RE: **Lot 19 Block 8 Volcano Cliffs Unit 5 SAD 227**
6823 Rimrock Rd. NW
Grading and Drainage Plan
Engineers Stamp Date 9/6/2021 (D10D024)
CO Certification Date: 2/15/2023

Based upon the information provided in your submittal received 3/7/2023, this plan for Certificate of Occupancy cannot be approved until the following comment are addressed.

ENGINEER'S SEAL  9/6/21 DAVID SOULE P.E. #14522	6823 RIMROCK GRADING AND DRAINAGE PLAN  Rio Grande Engineering 1606 CENTRAL AVENUE SE SUITE 201 ALBUQUERQUE, NM 87106 (505) 872-0999	DRAWN BY WCVJ DATE 9-02-21 210210083-LAYOUT-B-02-21 SHEET # JOB # 21021083
--	---	--

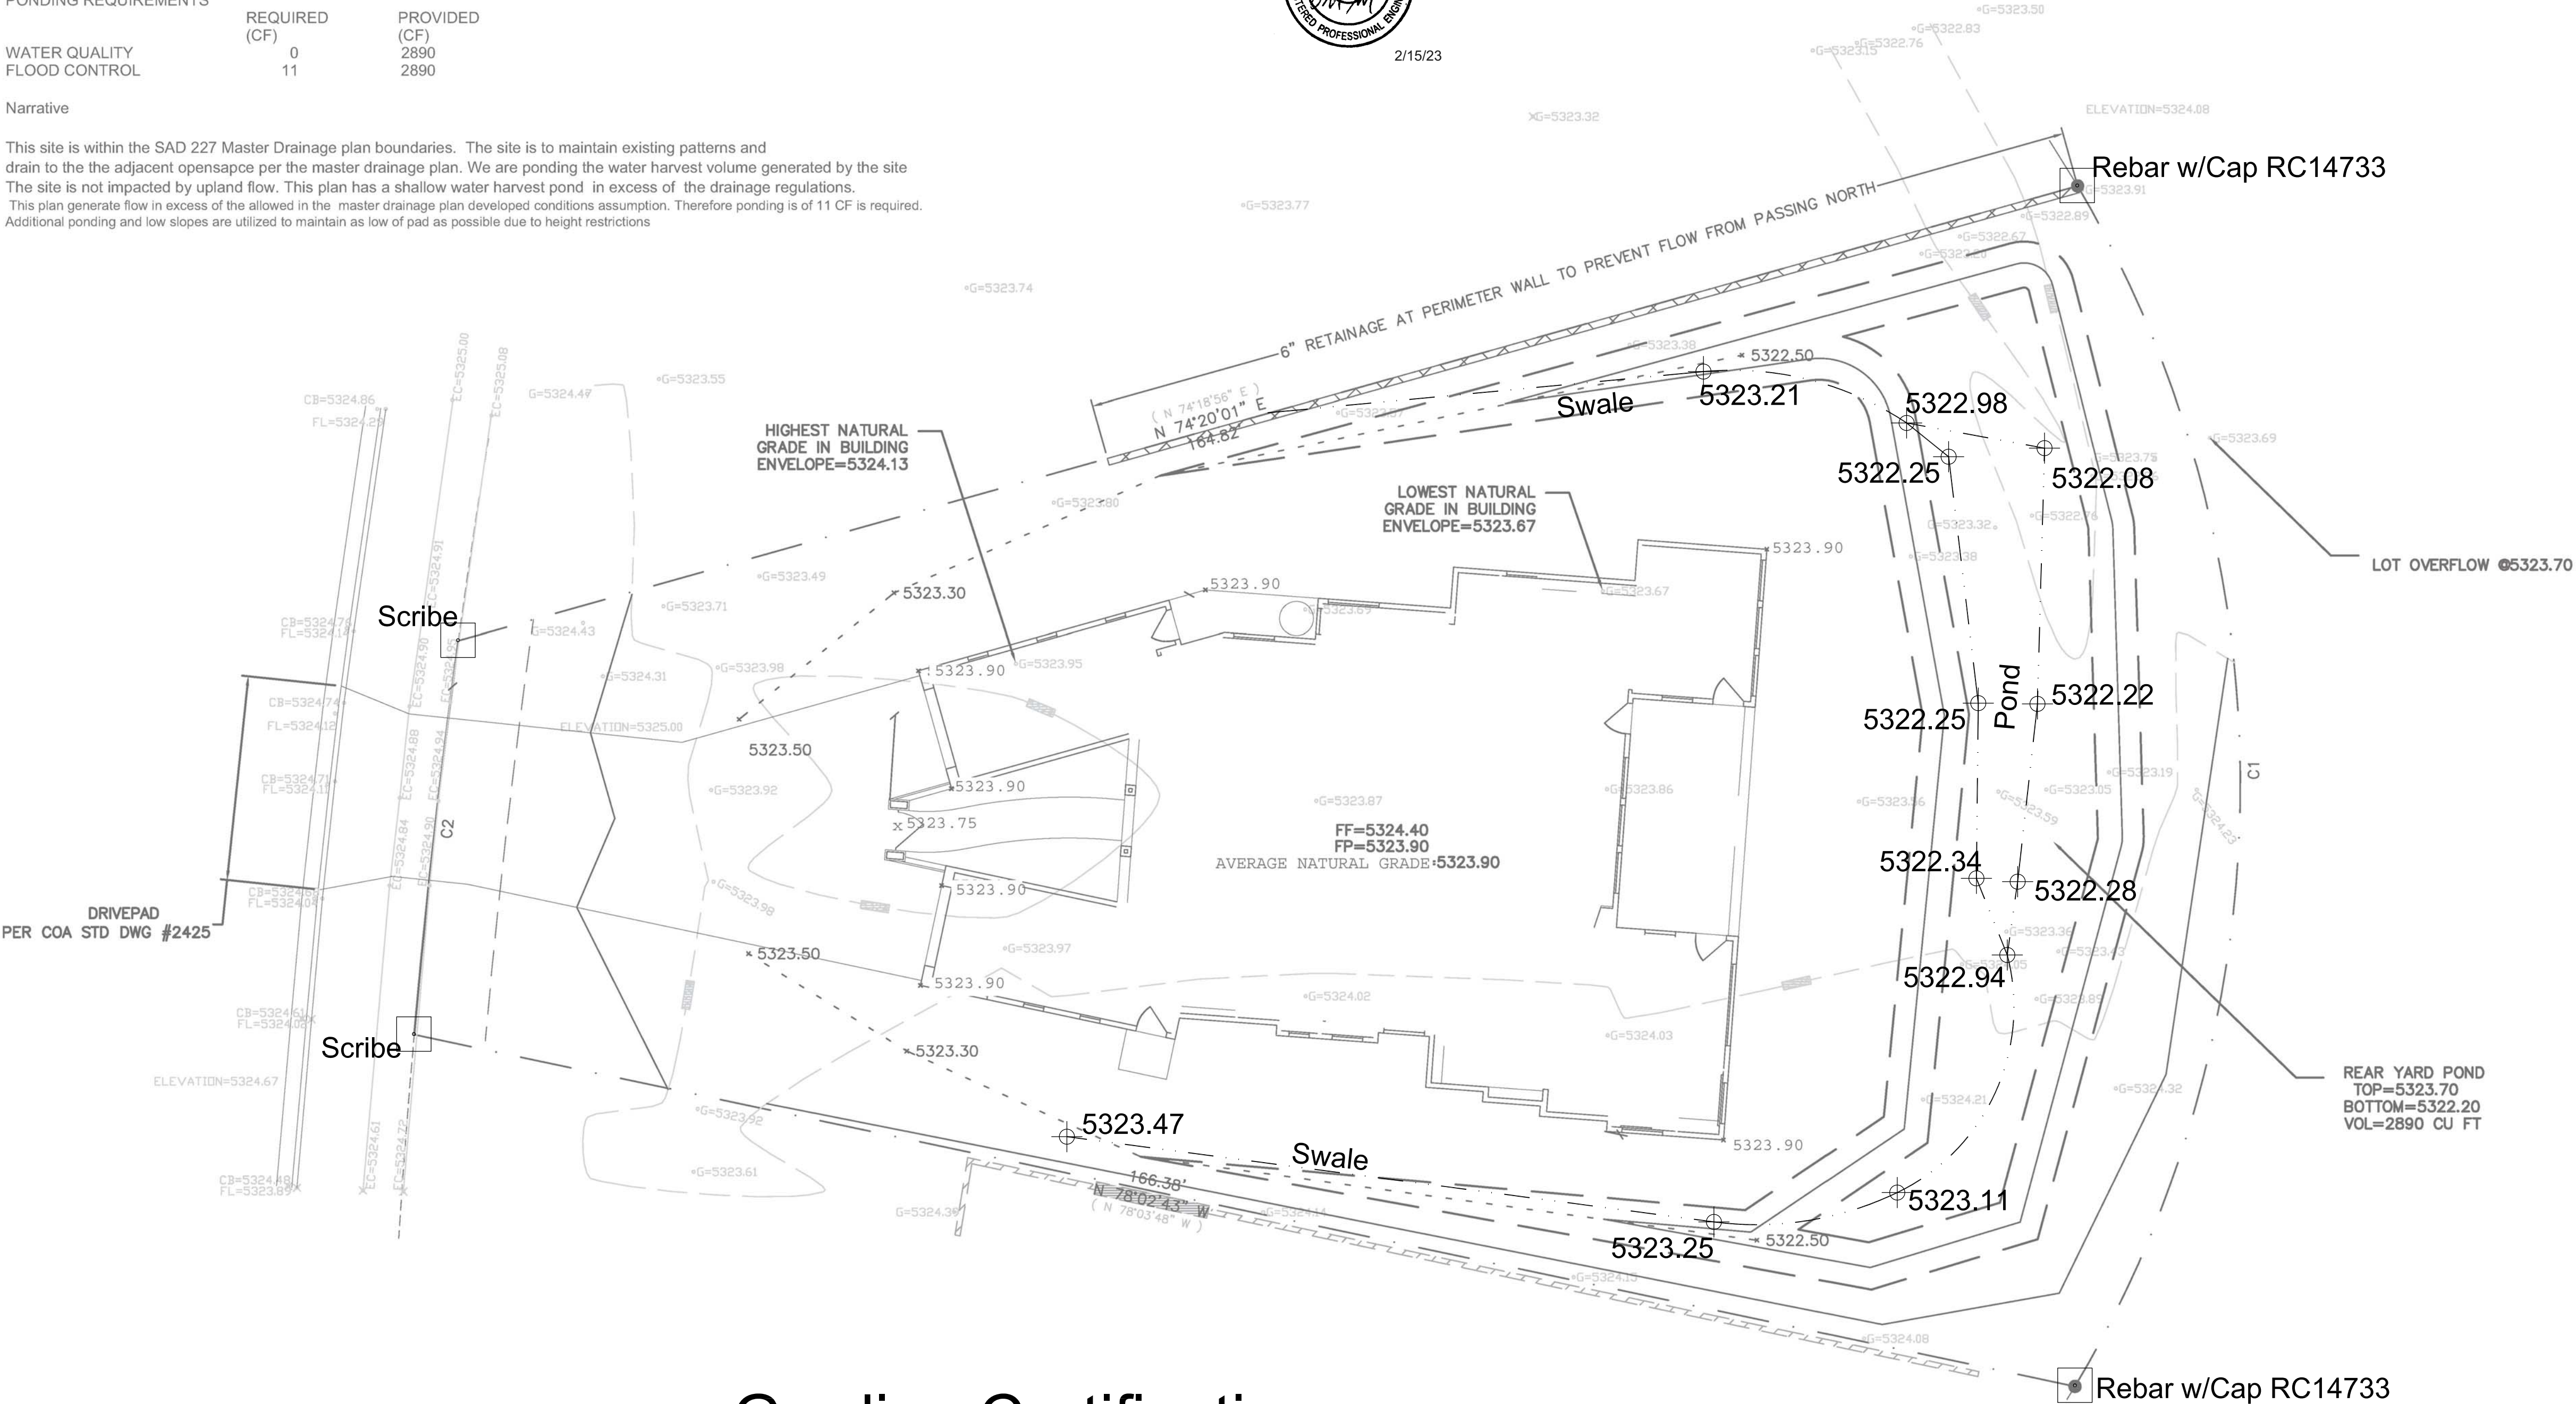
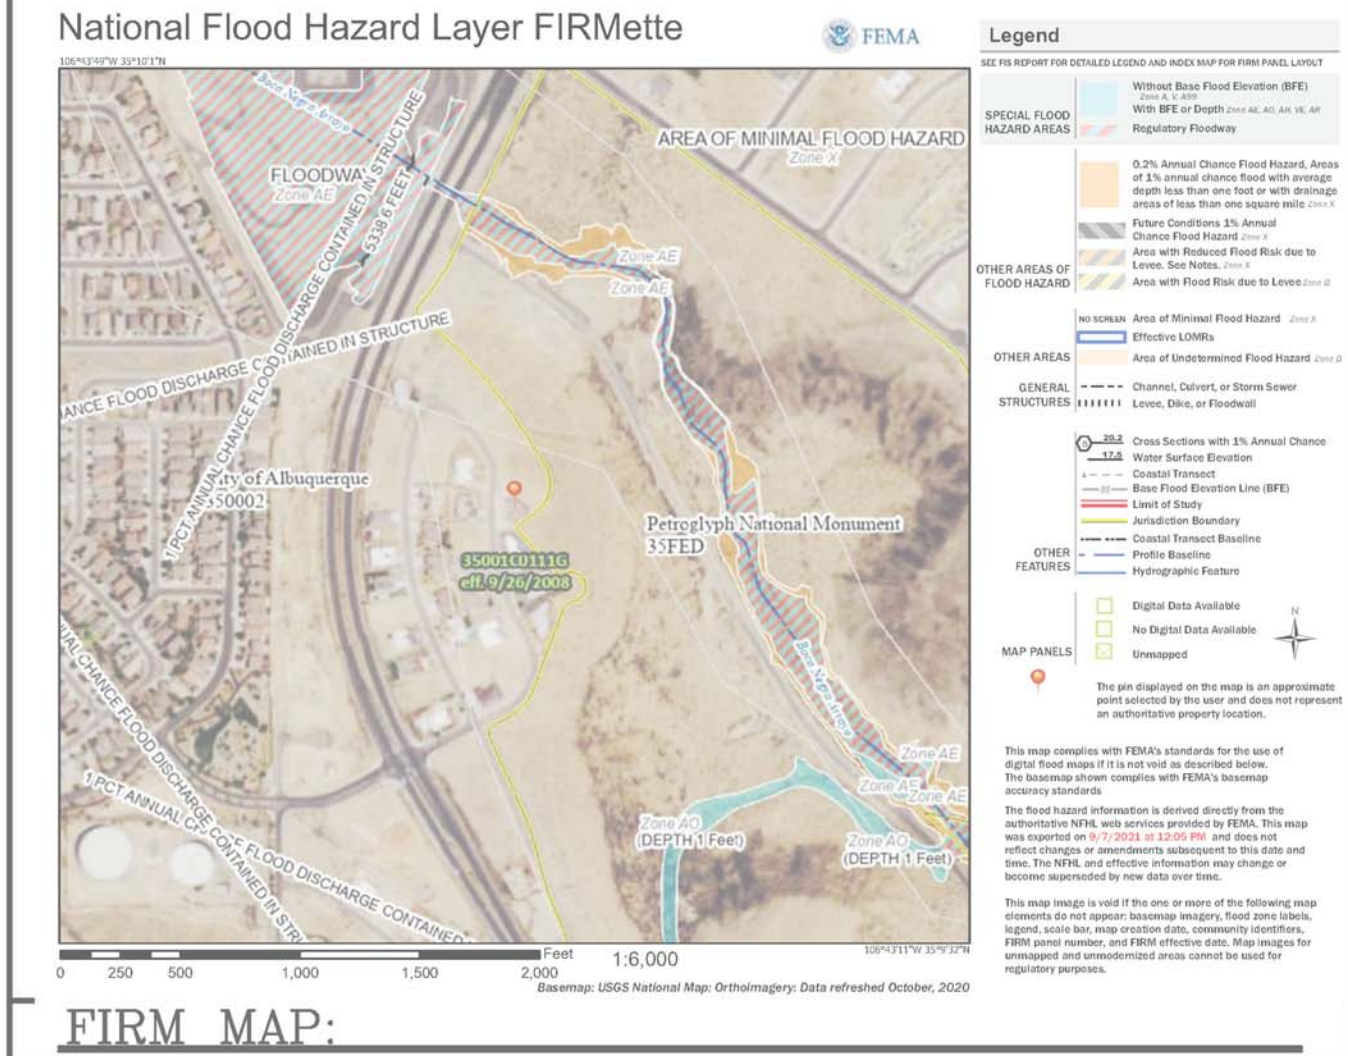
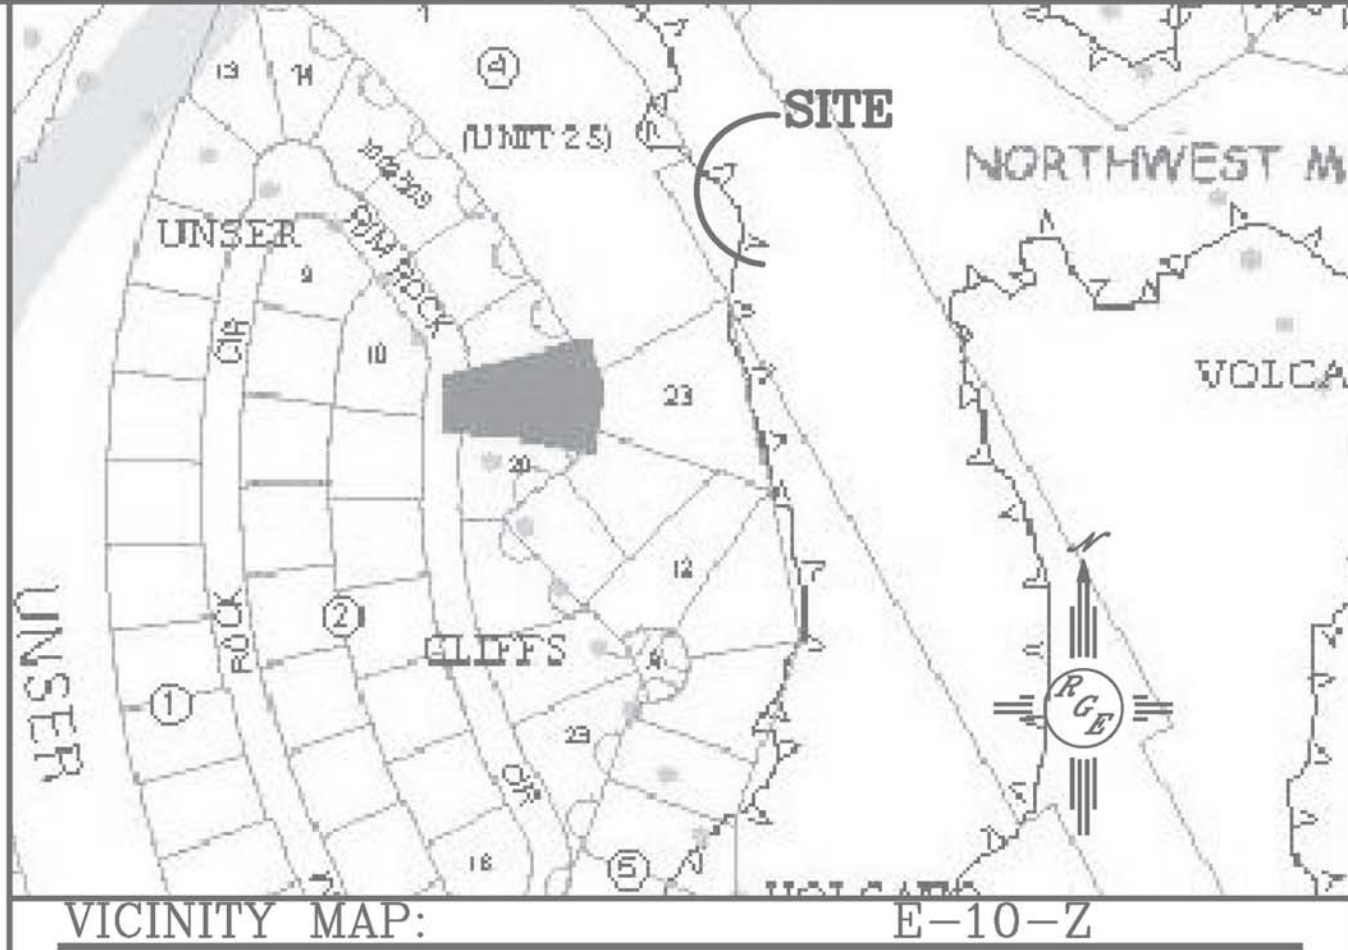
- The port-a-potty needs to be removed.
- Dirt must be removed from the public right of way. It appears dirt was used as a ramp to climb the curb.
